VIAERO FIBER NETWORKS, LLC CONSTRUCTION PLANS BACKBONE & DISTRIBUTION ROUTE EL PASO COUNTY, COLORADO

PCD File #
U231

Construction Drawings

VIAERO FIBER NETWORKS, LLC CONSTRUCTION PLANS

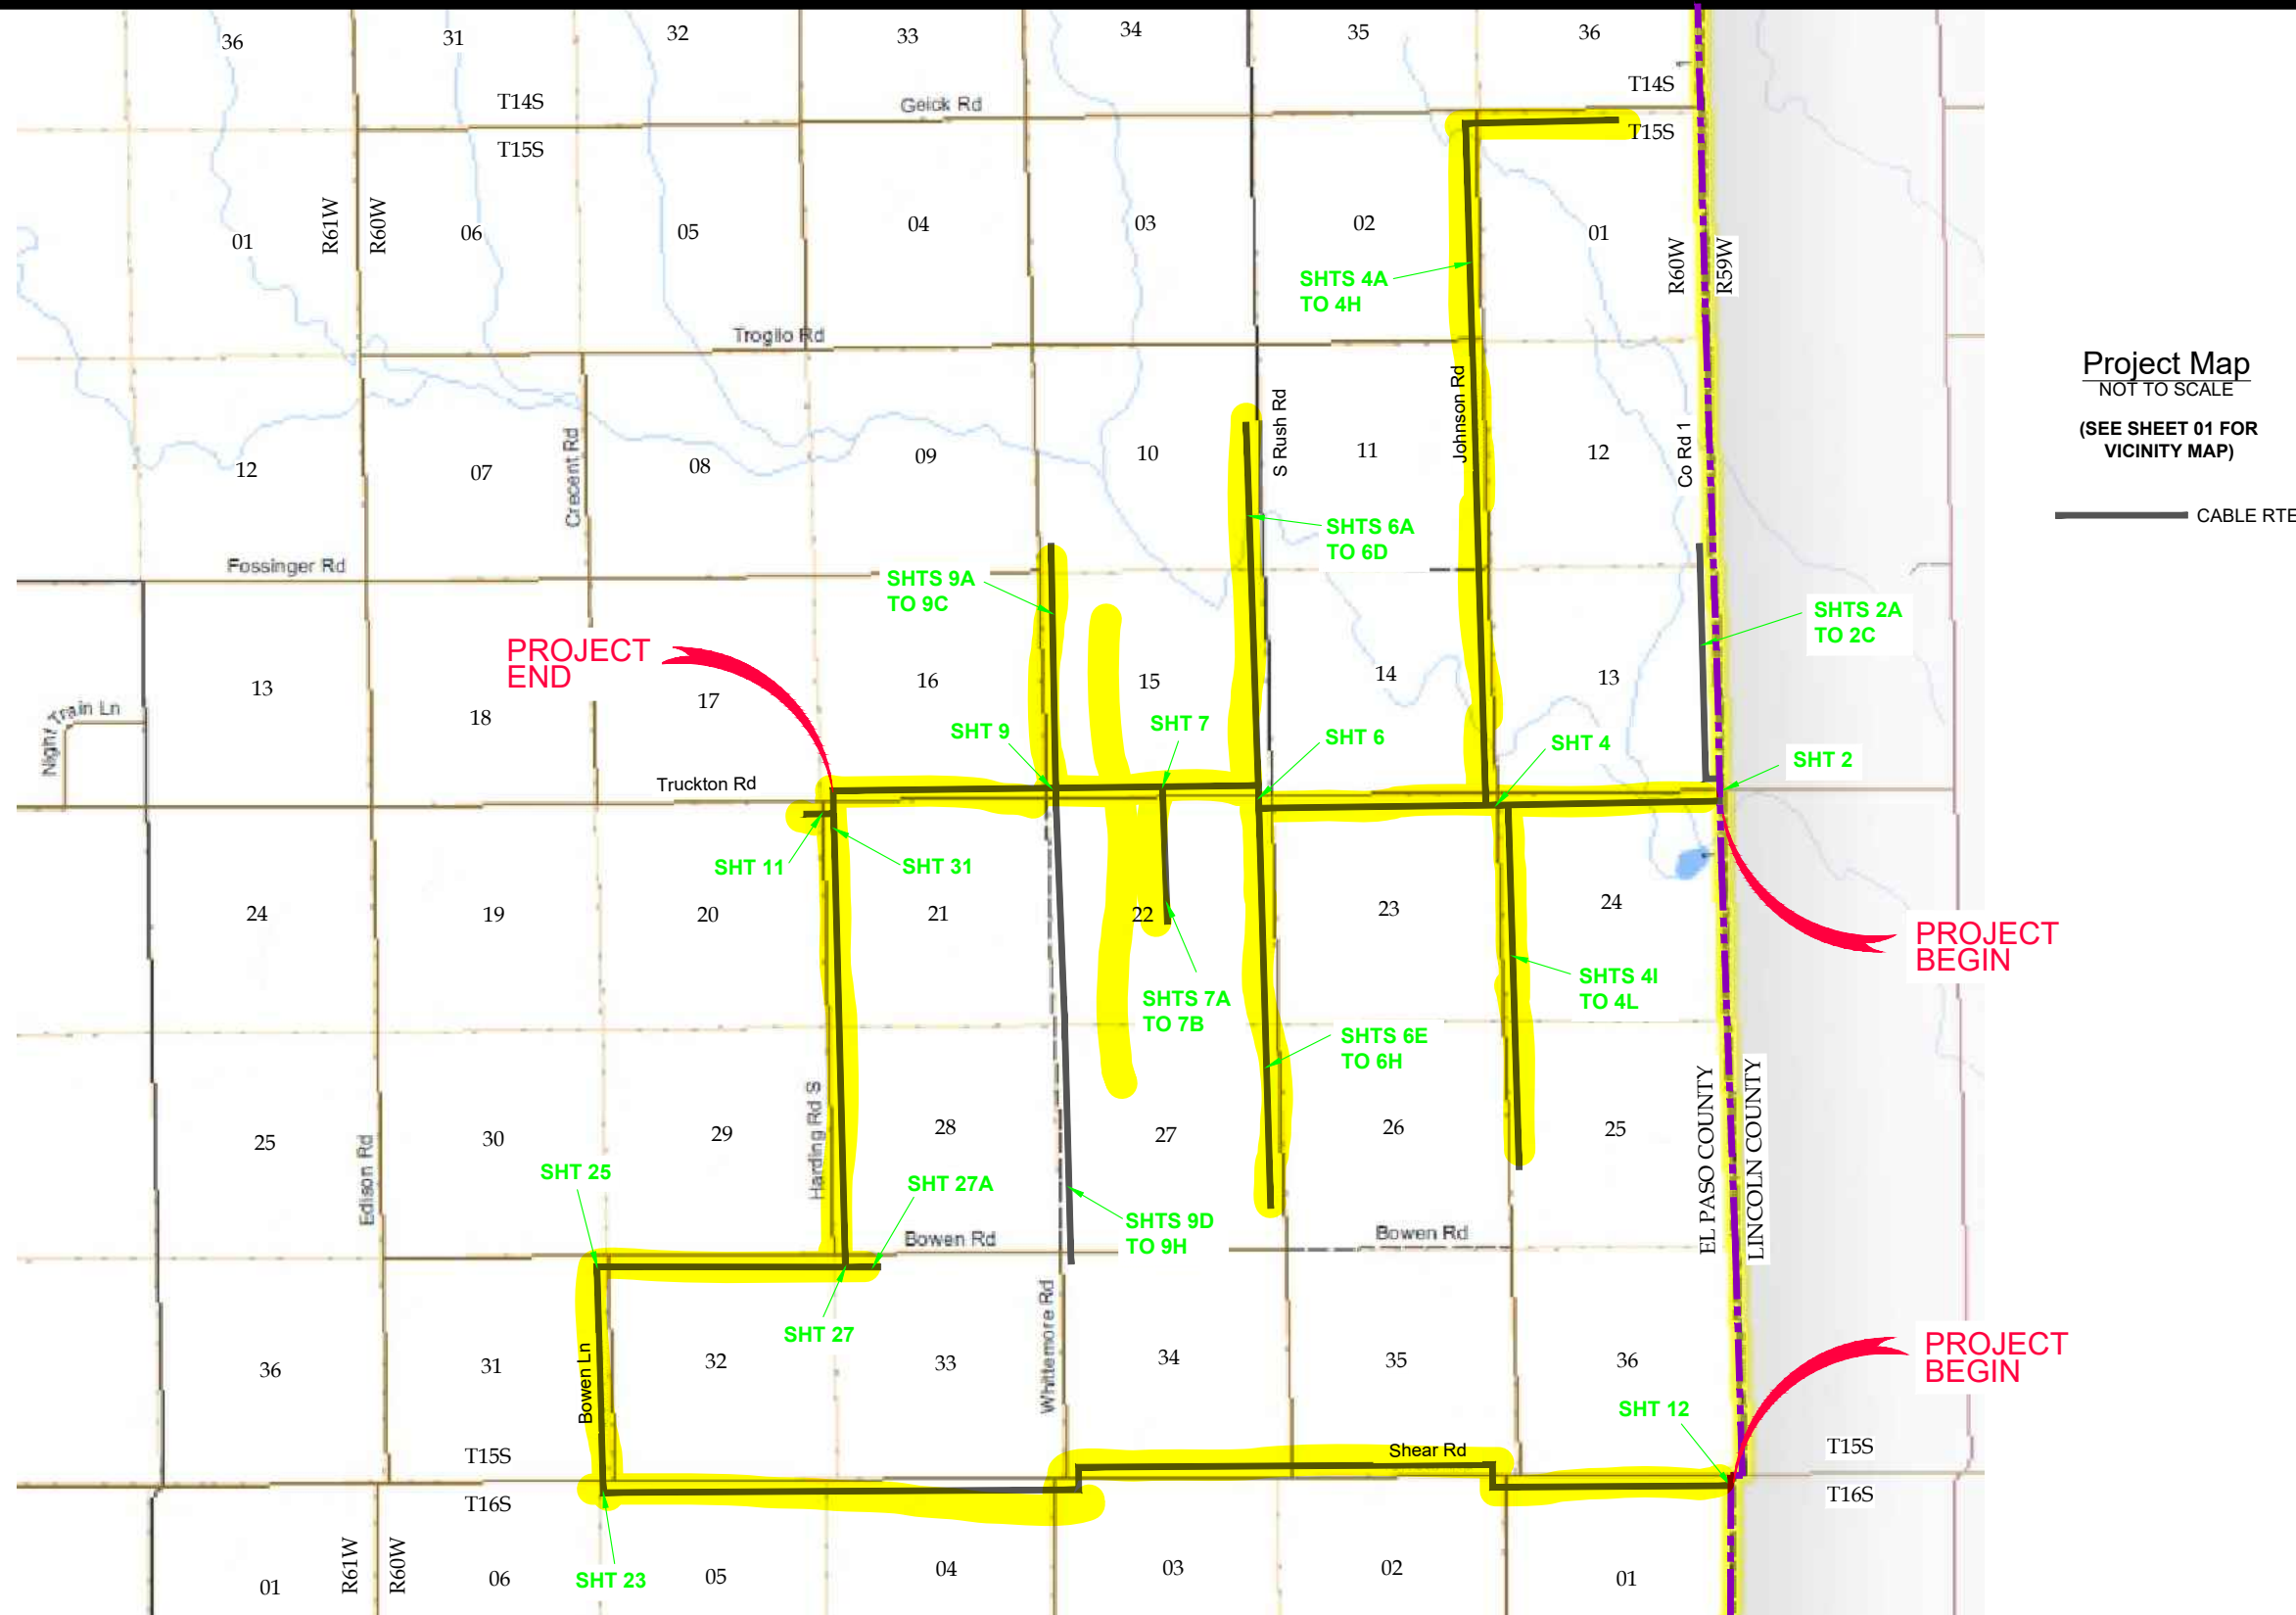
Please add EPC Std Construction notes and signature block below comment boxes
